Application No: FP/90/21/PD
Site Address: 23a Felpham Road Felpham PO22 7DA
Description of works: Notification of Prior Approval under Schedule 2, Part 3, Class M of the Town & Country (General Permitted Development (England) Order (as amended) for the change of use from shop (A1) to residential (C3).

Thank you for your internet representation made on 25th May 2021 which has been recorded as an objection with the comments as follows:

GROUND FLOOR PLAN 1:50

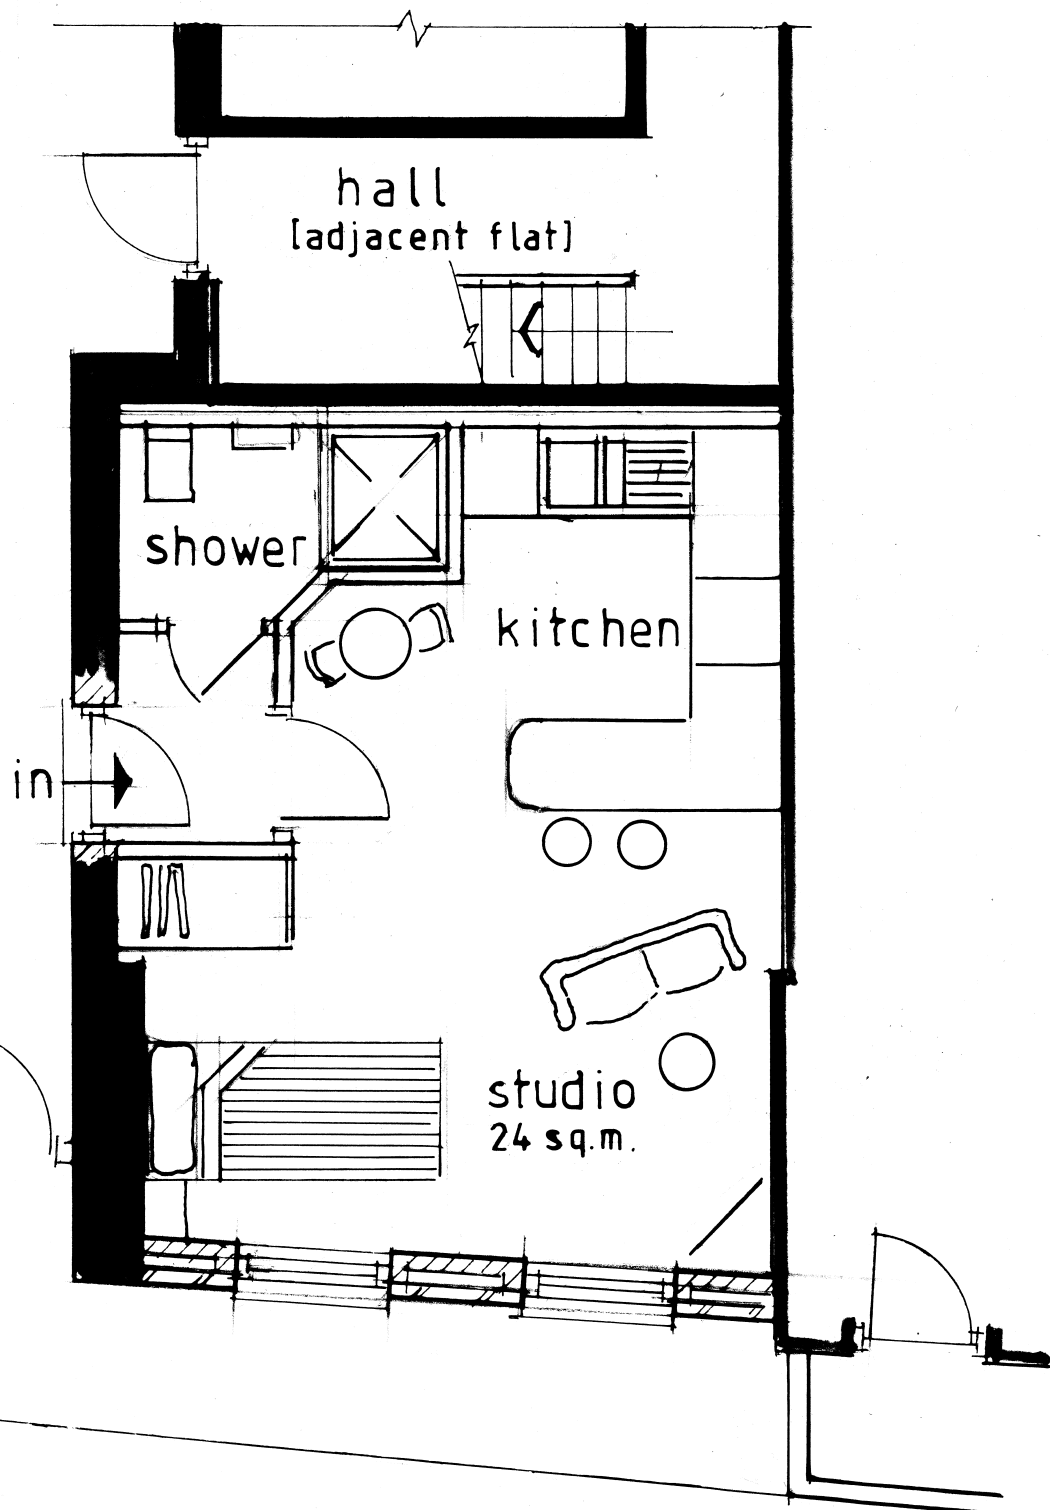
As the proposed kitchen is directly under my lounge, what provision is planned for the extraction of cooking odours, whilst minimising any noise or vibration? Also, where will any exterior venting be situated?

The plans show the placement of the proposed new doorway is directly under my chimney breast. I have no knowledge regarding when the chimney breast in the shop was removed & if it had the necessary support

The entrance path is very narrow where the new doorway is to be situated, with not much room to manoeuvre! I would assume, whoever moves in will struggle to get most furniture through the door unless it's flat-packed.

As all internal & external upper walls of the flat fall within my ownership, I wish to know if the proposed doorway & any RSJ (or equivalent support) or indeed, any ventilation shafts will encroach across onto my property? It is not very clear from the plans provided & I shall be reluctant to give my permission for any work that may affect my property -
